RE: 7450 N Mercer Way
Mercer Island, WA 98040
Permit # 1904-048

We have updated the plans to match the revised architecture and performed an in-house review. The structural plans have been revised as outlined below.

SHEET TITLE:
Foundation Plan

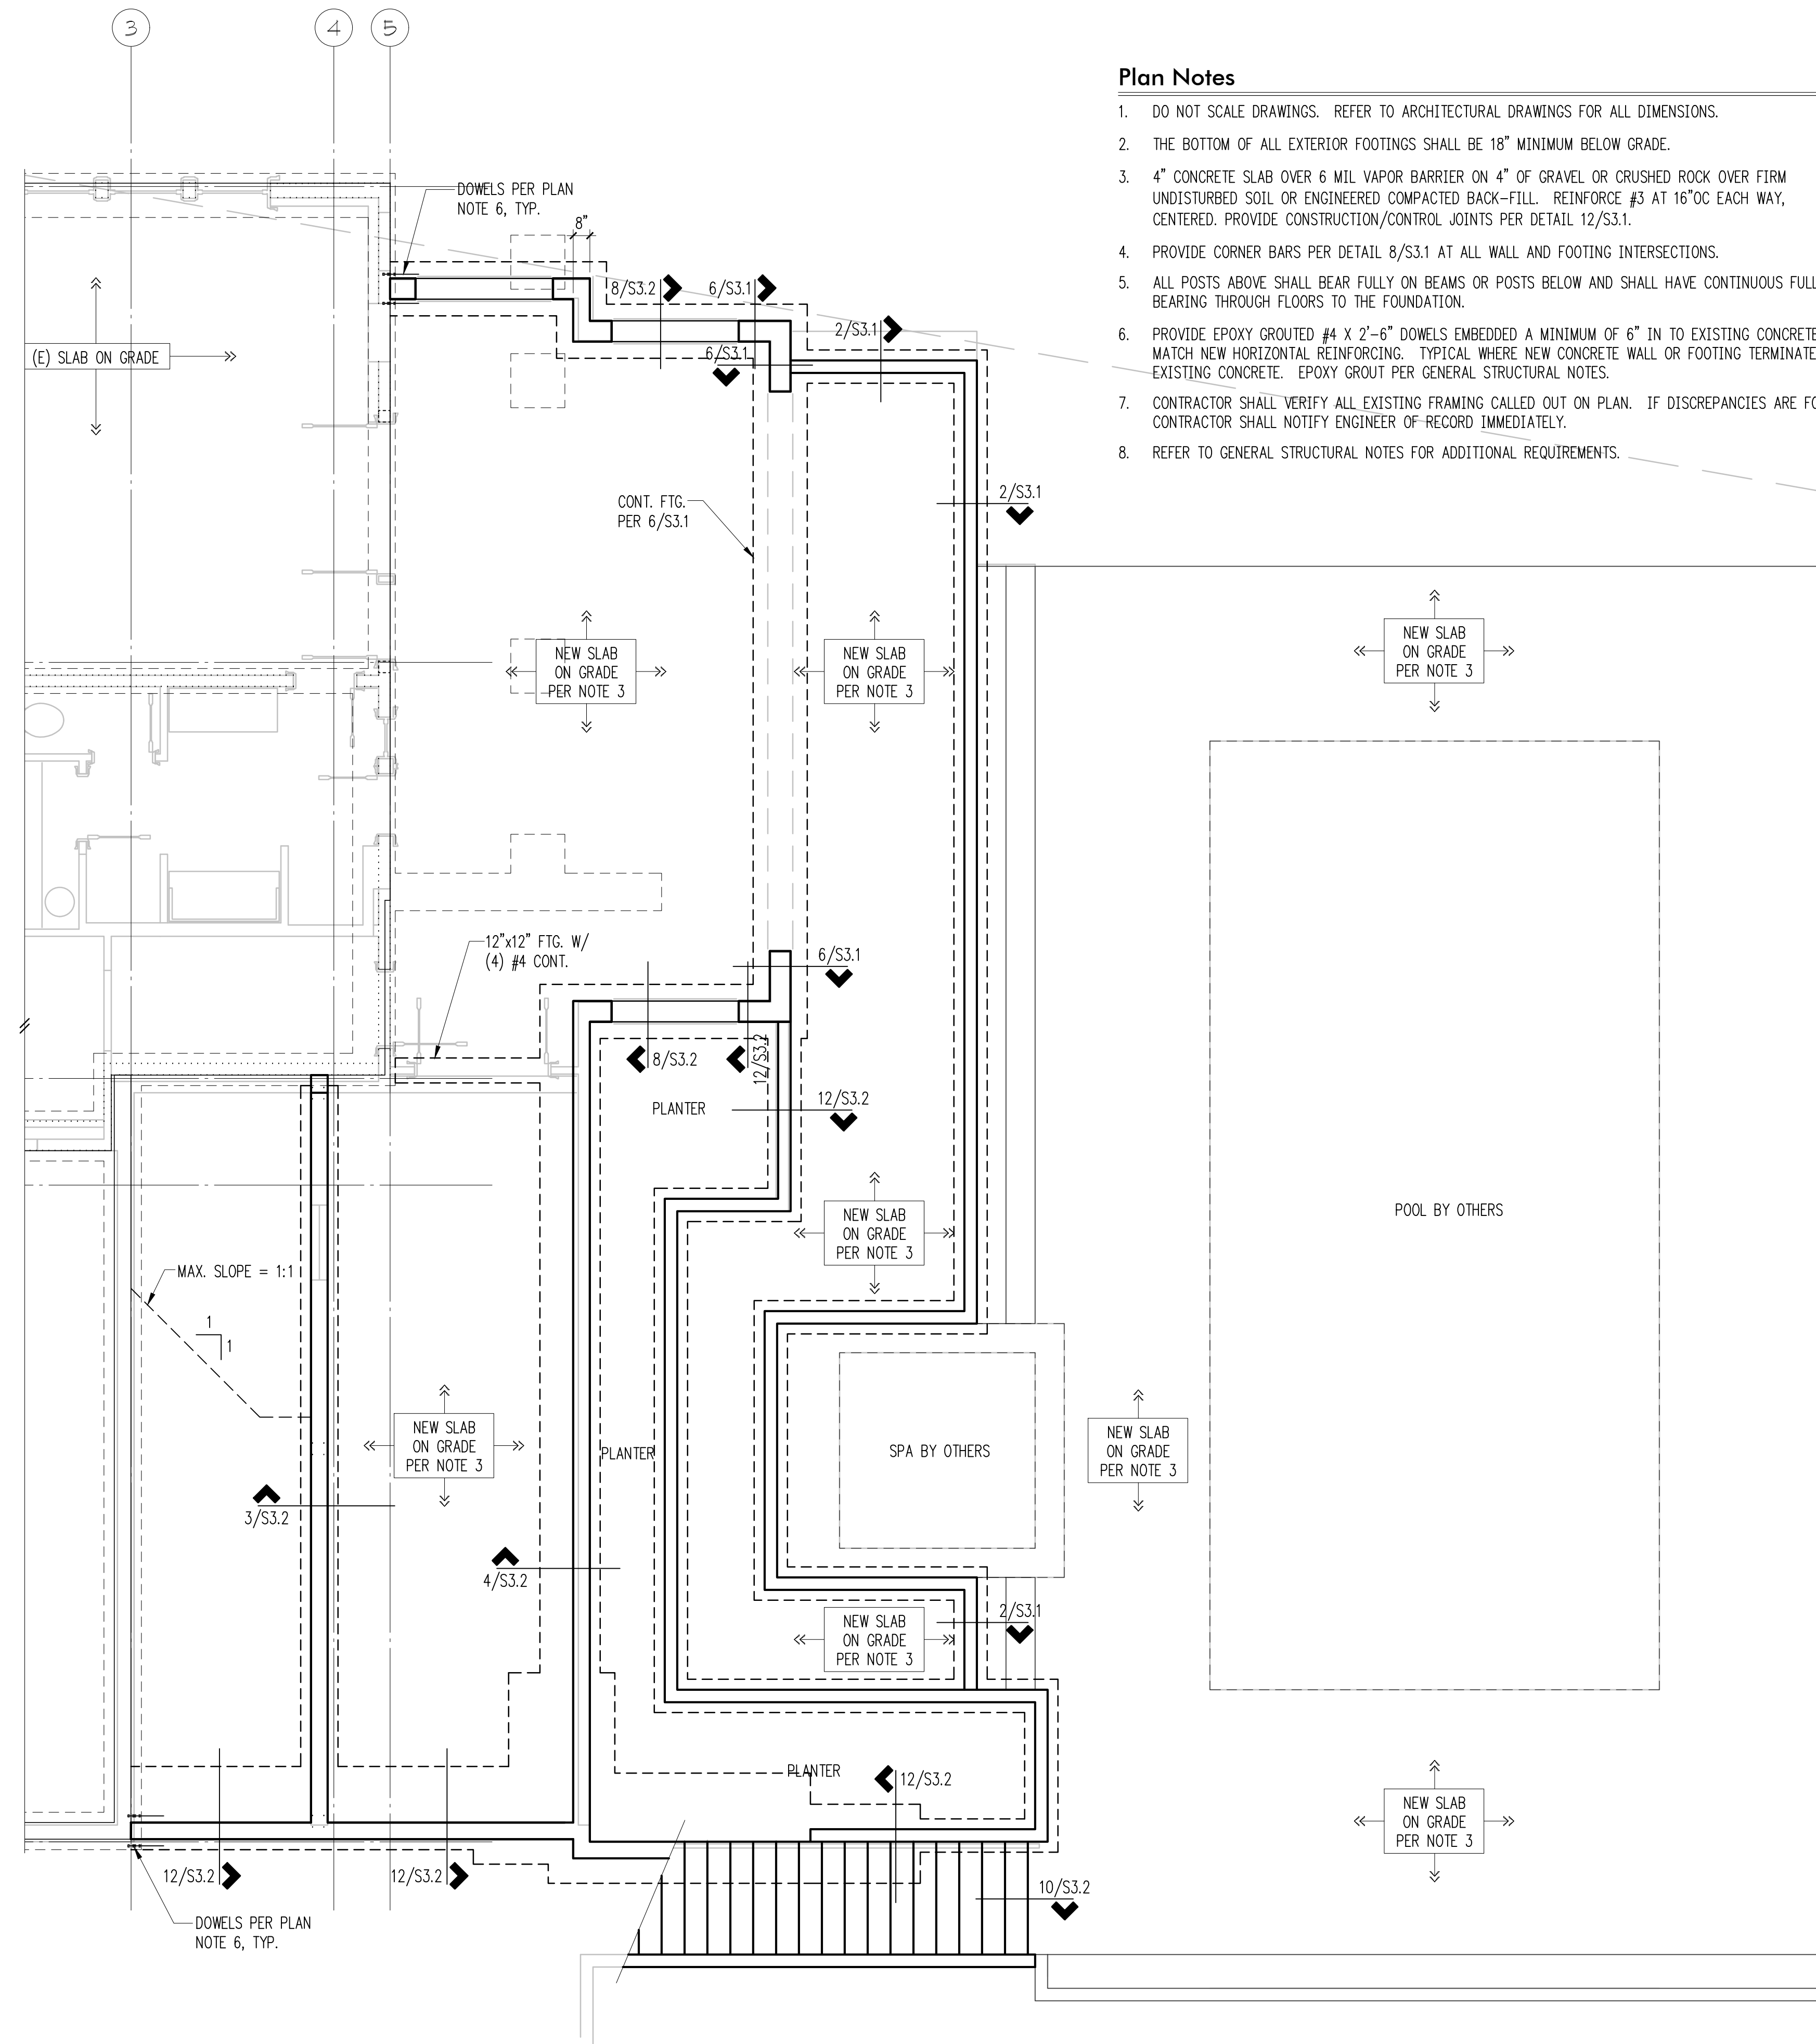
Sheet S2.1

- Wall openings and shifted on west elevation.
- Additional site walls shown on structural plans.
- New storage shown under east deck, structural drawings revised.
- Concrete stair added to east side of property.

SHEET TITLE:
Main Floor Framing Plan

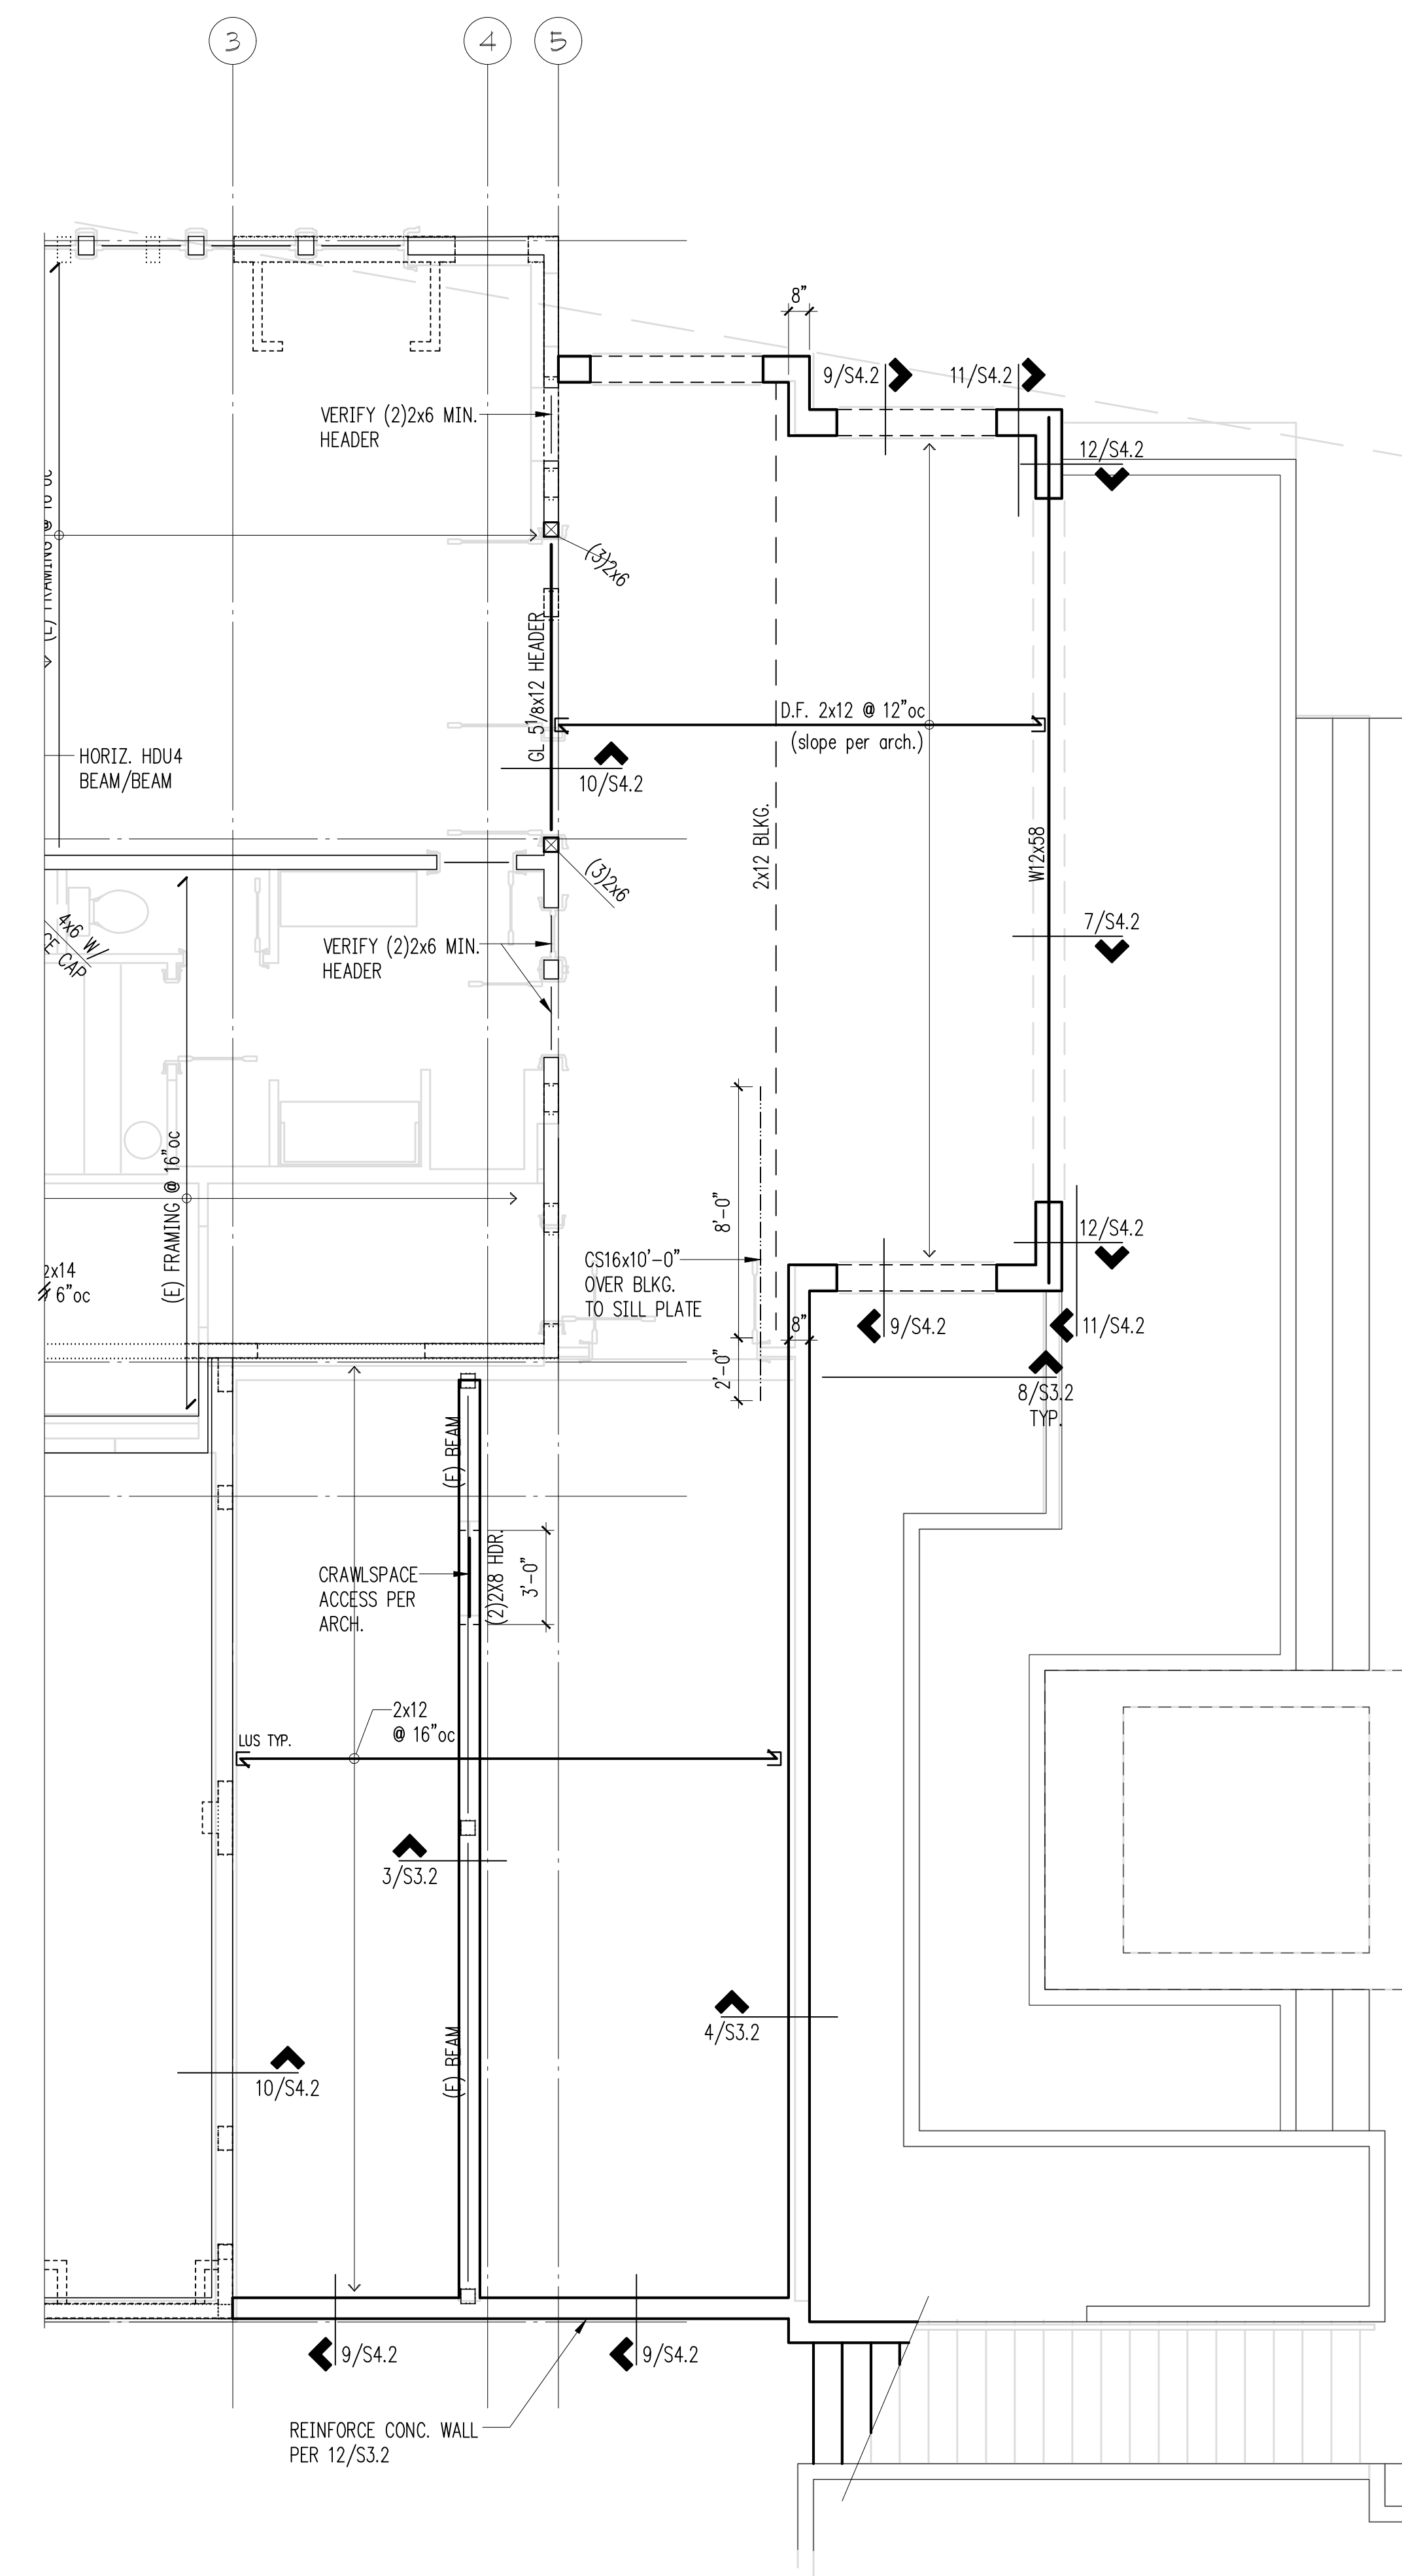
Sheet S2.2

- Deck framing joist spacing reduced to 12" on center.
- Connection from wide flange to concrete walls revised
- Storage room revisions same as S2.1.
